About the application

Application number: 2026/92450	
What is the application for?:	Demolition of existing workshop and erection of detached dwelling
Address of the site or building:	Workshop between, 12 & 14/16, Temple Street, Lindley, Huddersfield, HD3 3JG
Postcode:	HD4 6HF

Type of comment: An objection	
Do you wish your comments to be published on the website anonymously?	Yes

- Materials
- ① Reclaimed natural walling stone.
 - ② Through coloured rendered wall finish.
 - ③ Blue slate roof.
 - ④ Grey windows with natural stone heads, cills and mullions.
 - ⑤ Grey doors.
 - ⑥ Black rain water goods.
 - ⑦ Grey framed rooflights.
 - ⑧ Inset Solar Panel.

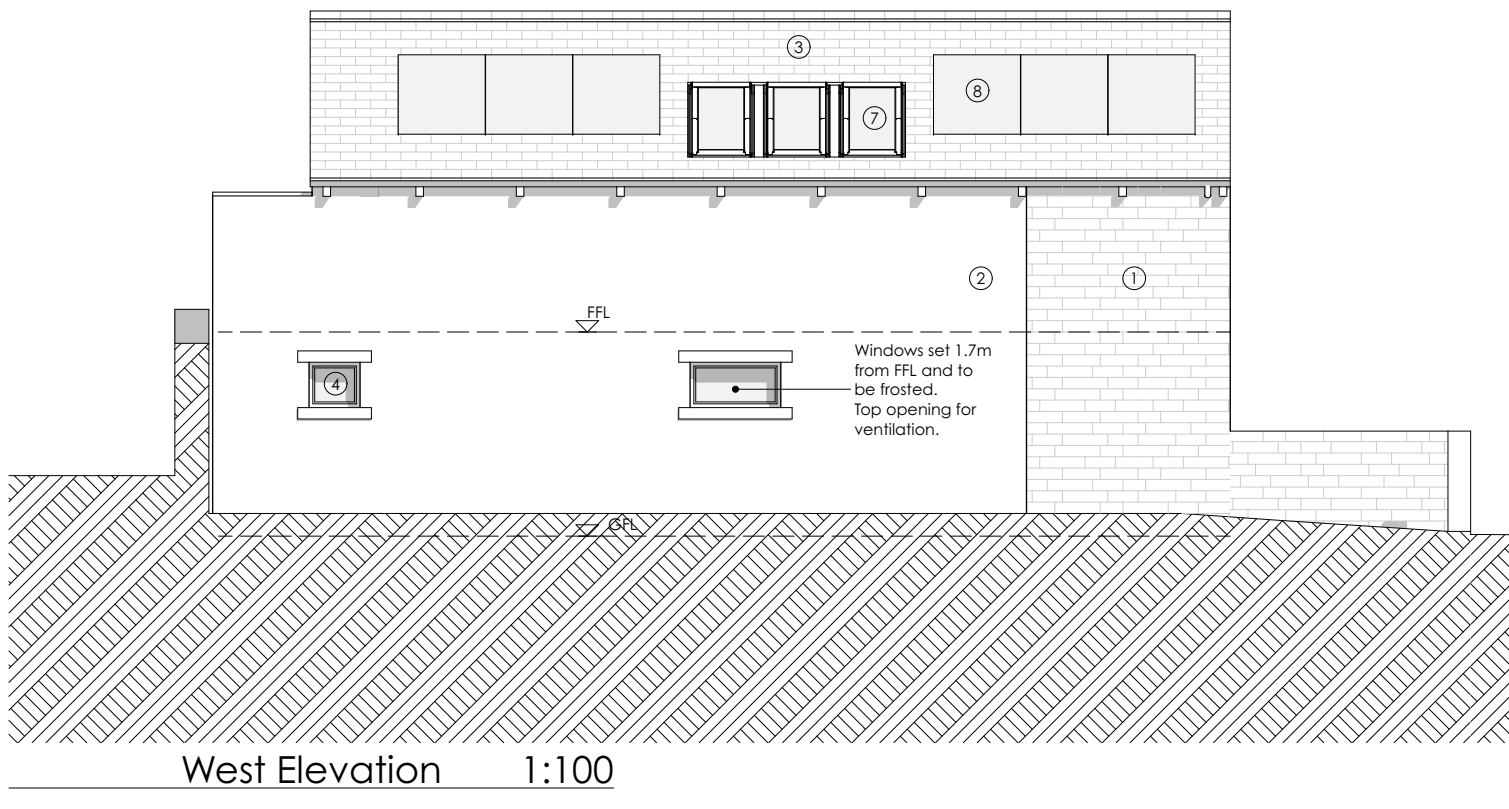
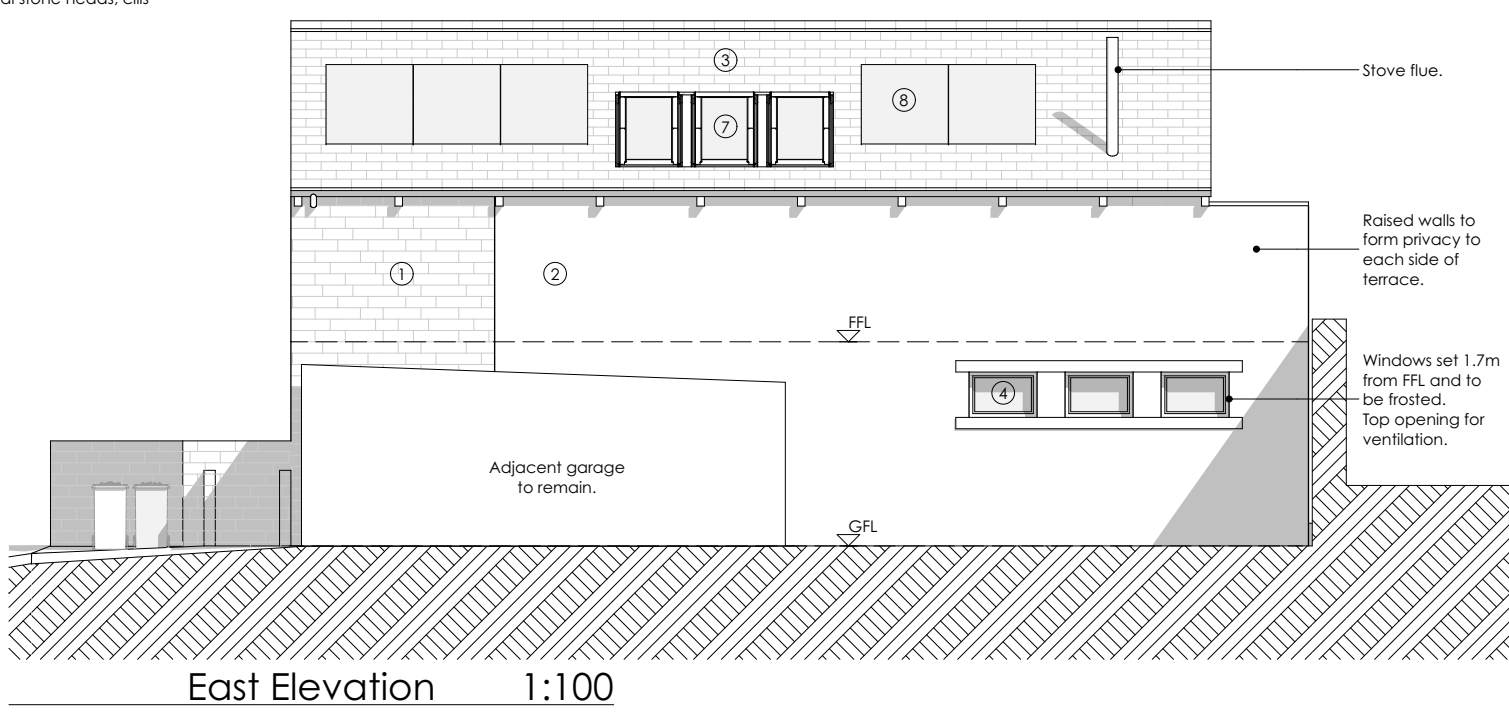
I am writing to formally object to the planning application referenced above. My property and private patio directly adjoin the boundary of the proposed development. While I note the applicant has attempted to satisfy privacy guidelines regarding overlooking by specifying obscured glass and a 1.7m finished floor level (FFL) restriction for the proposed side window, the current architectural design is unworkable and fundamentally flawed under property law for the following reasons:

Encroachment and Civil Trespass of Airspace: The proposed layout positions the new dwelling directly against my property boundary. Any outward-opening mechanism or top-hung hatch on this window will inevitably swing across the legal boundary line, causing a continuous and actionable civil trespass into my private airspace. A developer cannot rely on planning permission to overwrite established property boundaries.

Impact on Amenity and Safety: The airspace into which this window will open sits directly above my private outdoor patio. An outward-opening window creates an unreasonable safety hazard to anyone utilising my patio and restricts the full, unhindered enjoyment of my own land.

Lack of Maintenance Feasibility: Because the window opens directly over my boundary line, it cannot be cleaned, repaired, or maintained by the future occupiers without physically entering my private property. I do not grant permission for access to my land for routine window maintenance, rendering this element of the building design unsustainable.

Requested Action / Condition: I strongly urge the Planning Committee or Case Officer to refuse this layout in its current form. Should the council be minded to approve this application despite this flaw, I request that a strict, legally binding planning condition be attached to the decision notice. This condition must mandate that this specific window be entirely fixed-shut (100% non-opening) or designed as an inward-opening (tilt-and-turn) window only, ensuring that no part of the frame, glass, or mechanism can ever breach the boundary line into my property.

The current architectural drawings indicate that the proposed building's east wall is positioned directly on the boundary line. Consequently, any standard roof eaves, fascia boards, or guttering systems attached to this roofline will inevitably project outwards and overhang directly into my private property and over my patio.

This constitutes a permanent civil trespass of my airspace and poses a significant risk of water runoff discharging onto my land. I request that the developer be required to amend their plans to set the entire building footprint back from the boundary line, ensuring that all guttering, eaves, and subterranean foundations remain 100% within the applicant's own legal land boundaries.
